SUNNICA ENERGY FARM

8.97 Applicant's Response to LPA Deadline 6 Submissions

8.97 Applicant's Response to LPA Deadline 6 Submissions

2.1 Interested party – Cambridgeshire County Council – D5

ACM-60589004-AMR-DR-0038

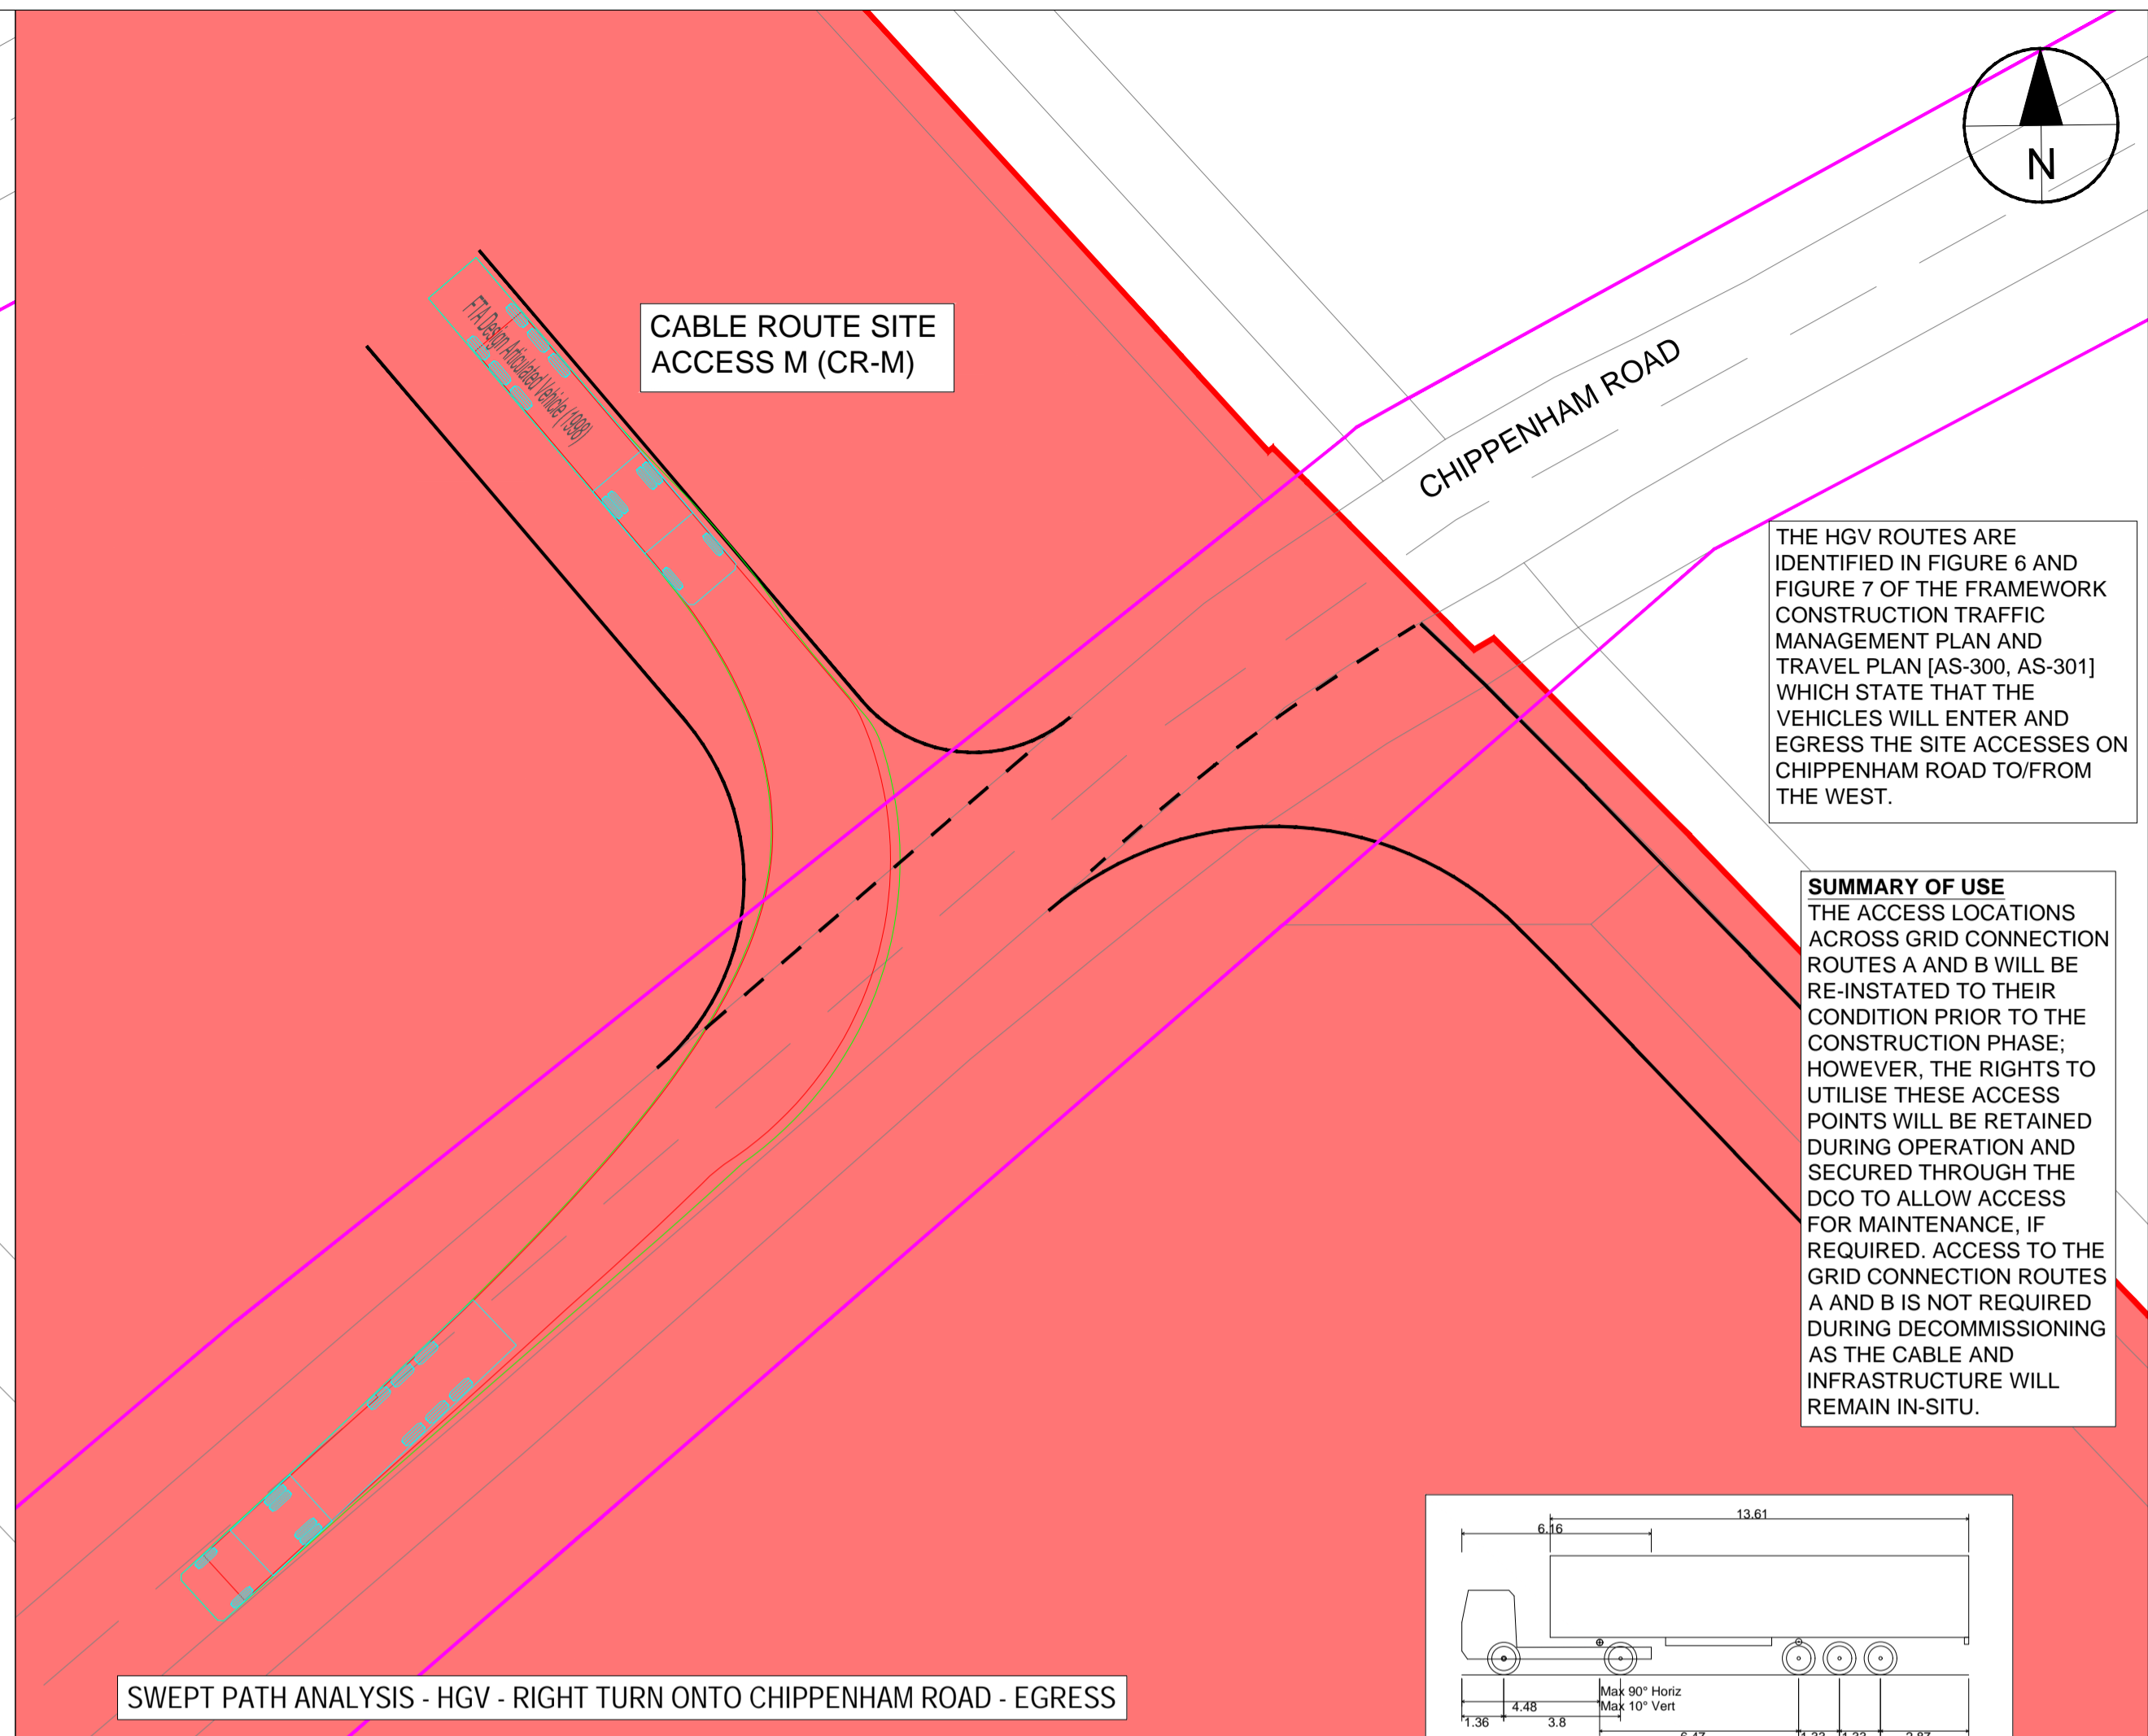
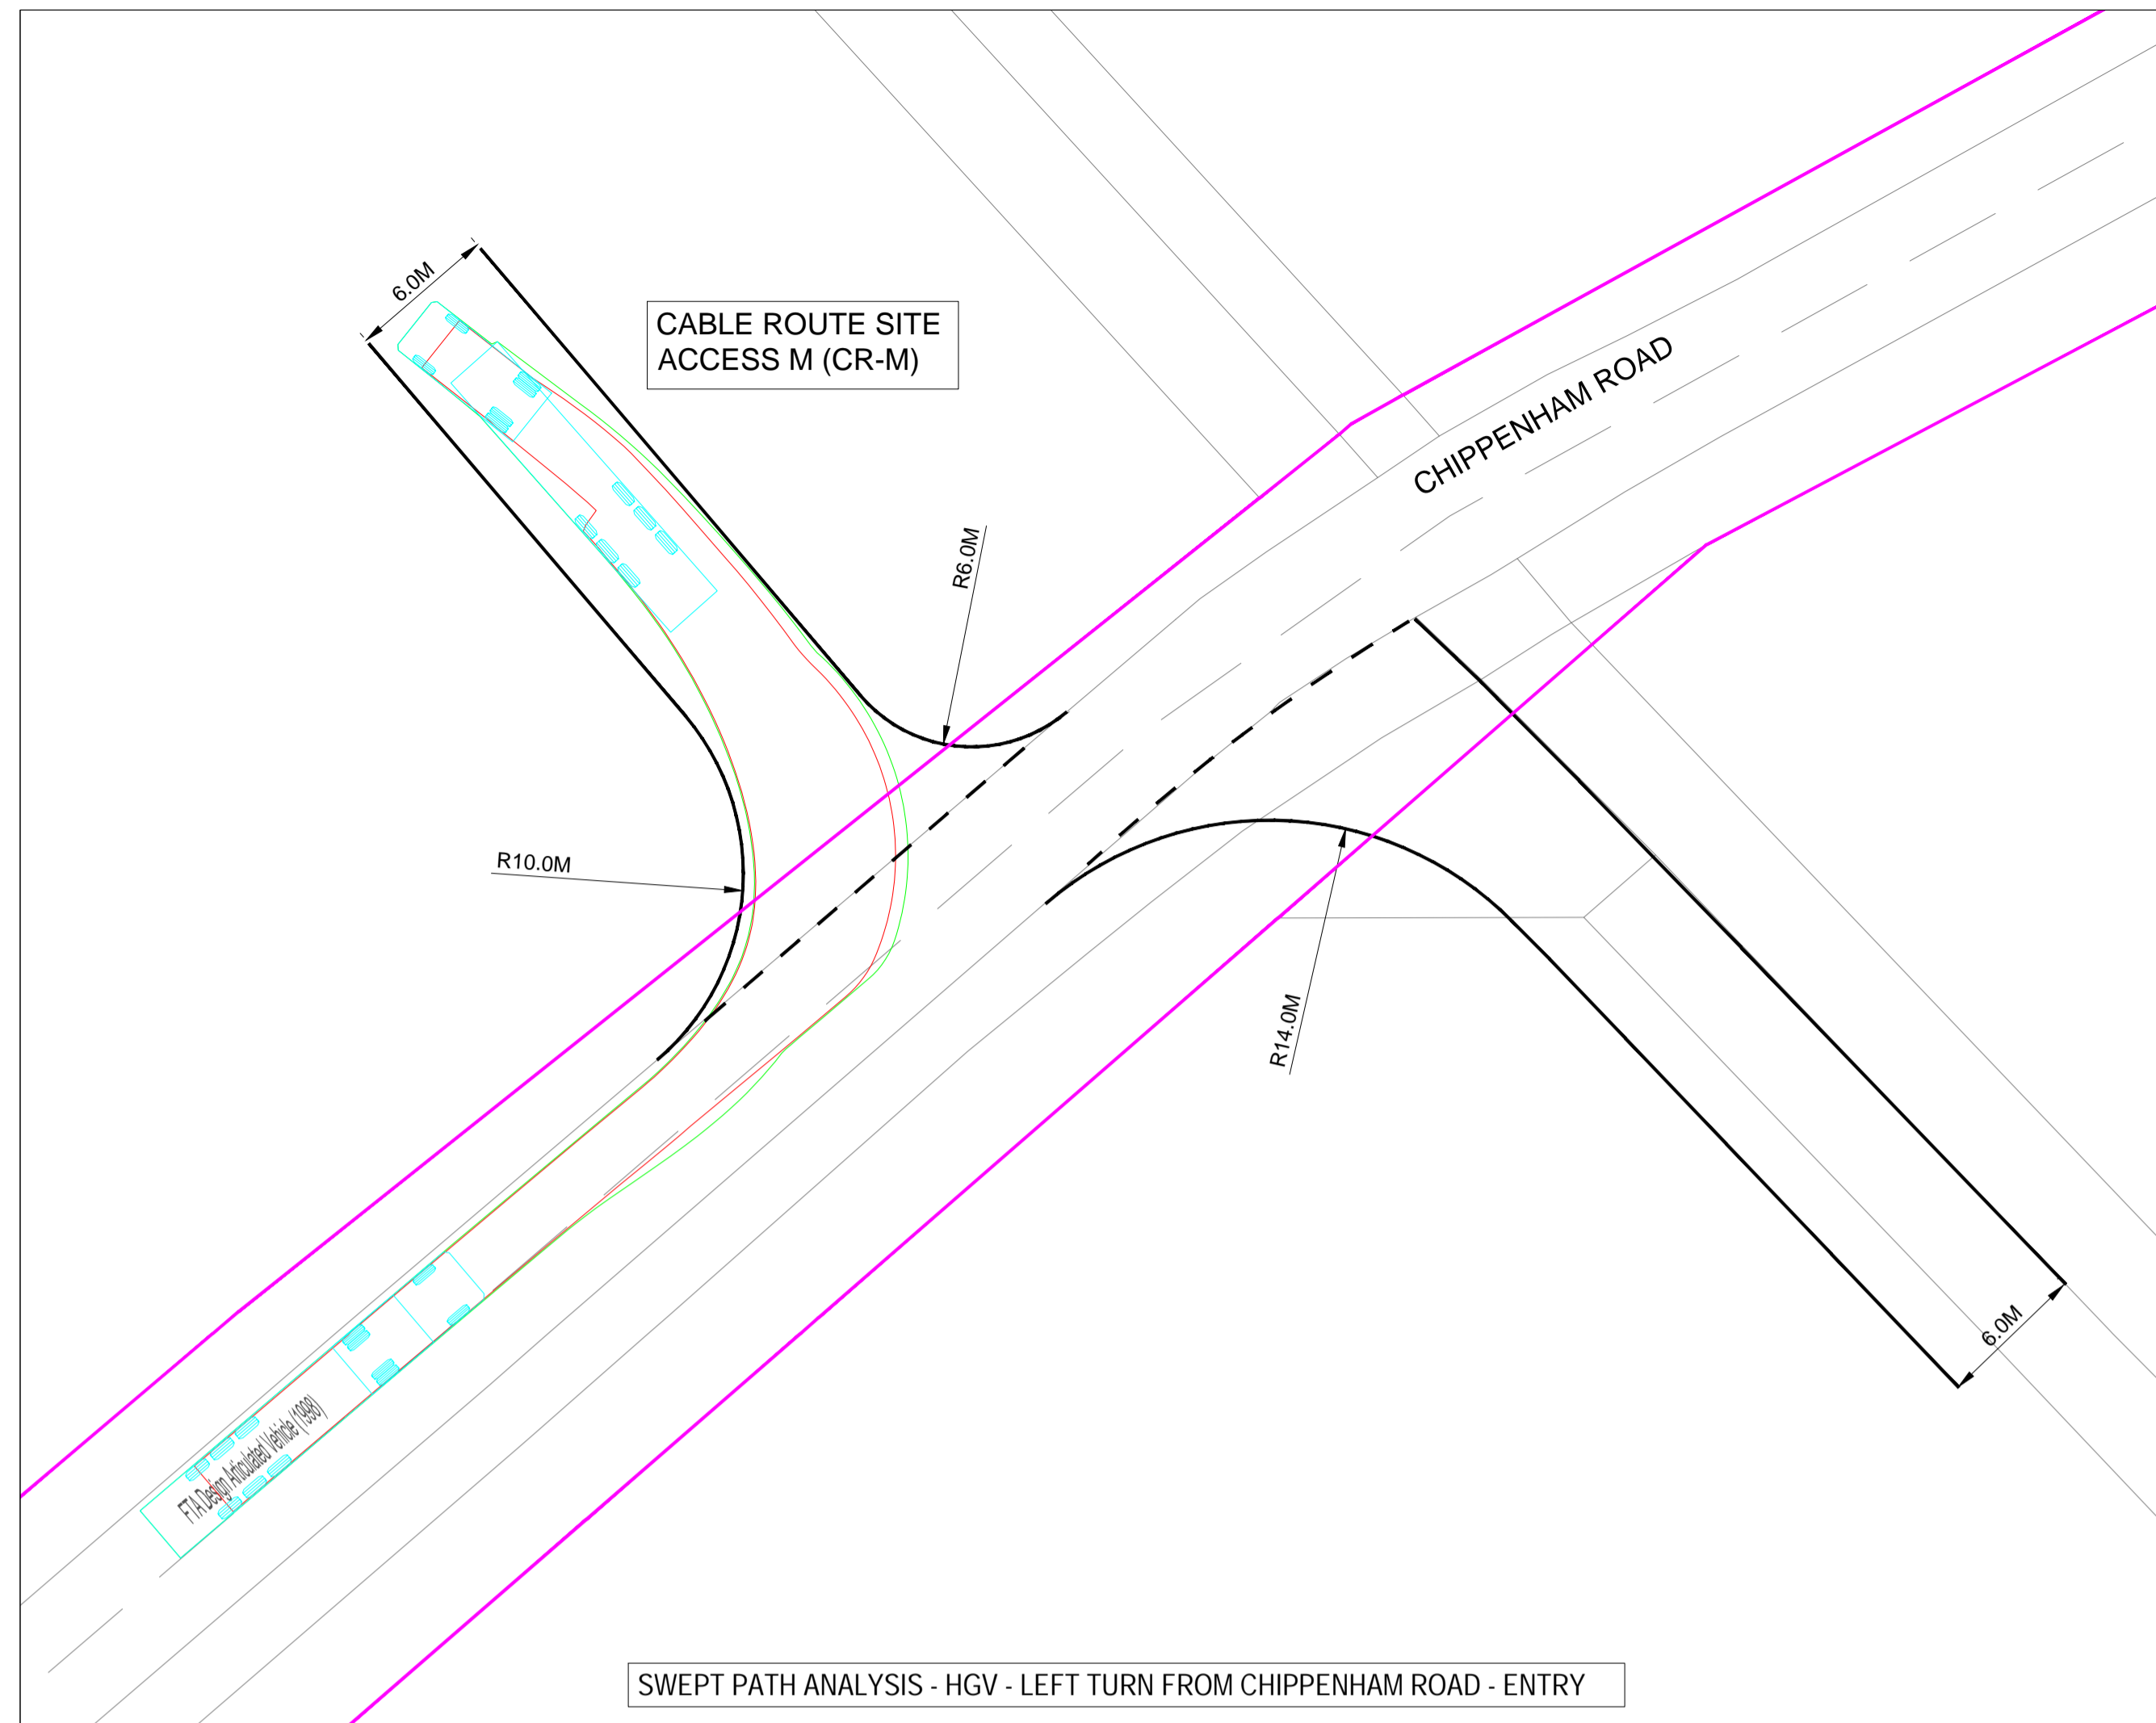
Topic	Deadline and Document Ref	Summary of issue raised	Applicant Response
			safe and suitable access can be achieved in any eventuality.
Plan ACM-60589004-AMR-DR-0038	Cable Route Access N. Snailwell Road, Chippenham.	<p>The proposal is to utilise an existing unmade field access, with improvements including 14m radius to the east but no radius to the west. This would not be considered acceptable unless it can be proven that traffic will not enter the access from the east during any phase of its use. It is also noted that any radius on the eastern side would conflict with an adjacent access and any proposal would therefore need to accommodate this.</p> <p>The swept path detail shown does not demonstrate the ability for two vehicles to pass, and while vehicle movements will be managed during the operational phase to avoid opposing flows, it is unclear how the access will be used during the operational phase, or how such conflict will then be managed. It is therefore unclear whether safe access is provided.</p> <p>No visibility splays have been detailed to demonstrate that visibility appropriate to the speed of the road can be achieved within the DCO or Highway boundary. Chippenham Road is planted with low trees to the west and with a dense hedge to the east, creating a significant risks obstruction of visibility; this is of particular concern to the east, with this access located on the inside of the bend. It is not therefore possible to confirm that safe access can be achieved</p>	<p>The Site Access Drawings in Annex C of the Framework Construction Traffic Management Plan [REP5-015] will be updated at Deadline 7. Access radii are shown on the plans, which demonstrate that swept path analysis of vehicles can be accommodated. For clarity, the radius on the plan is to the west, not the east as per CCC's comment. No construction traffic will enter from the east, as is secured through the HGV routes. The surface construction is a matter for detailed design stage of the project. Other comments relating to detailed design are noted and will be addressed at the appropriate design stage of the project.</p> <p>The Applicant's response to EXQ3.9.9 includes a table further demonstrating that there will be no intensification of use of this access in the operational phase. Thus retention of the existing field access in its current form is appropriate for the operational phase. As is set out in response to EXQ3.9.9, there will be no requirement for Sunnica LGVs or HGVs to access the cable route sites, unless a fault is identified remotely. If a fault is identified, the Applicant will be required to agree access arrangements with the LHAs to ensure safe and suitable access. If required, the DCO powers enable the Applicant to re-introduce the Temporary Traffic Management applied during the construction phase. This provides confidence that safe and suitable access can be achieved in any eventuality.</p>
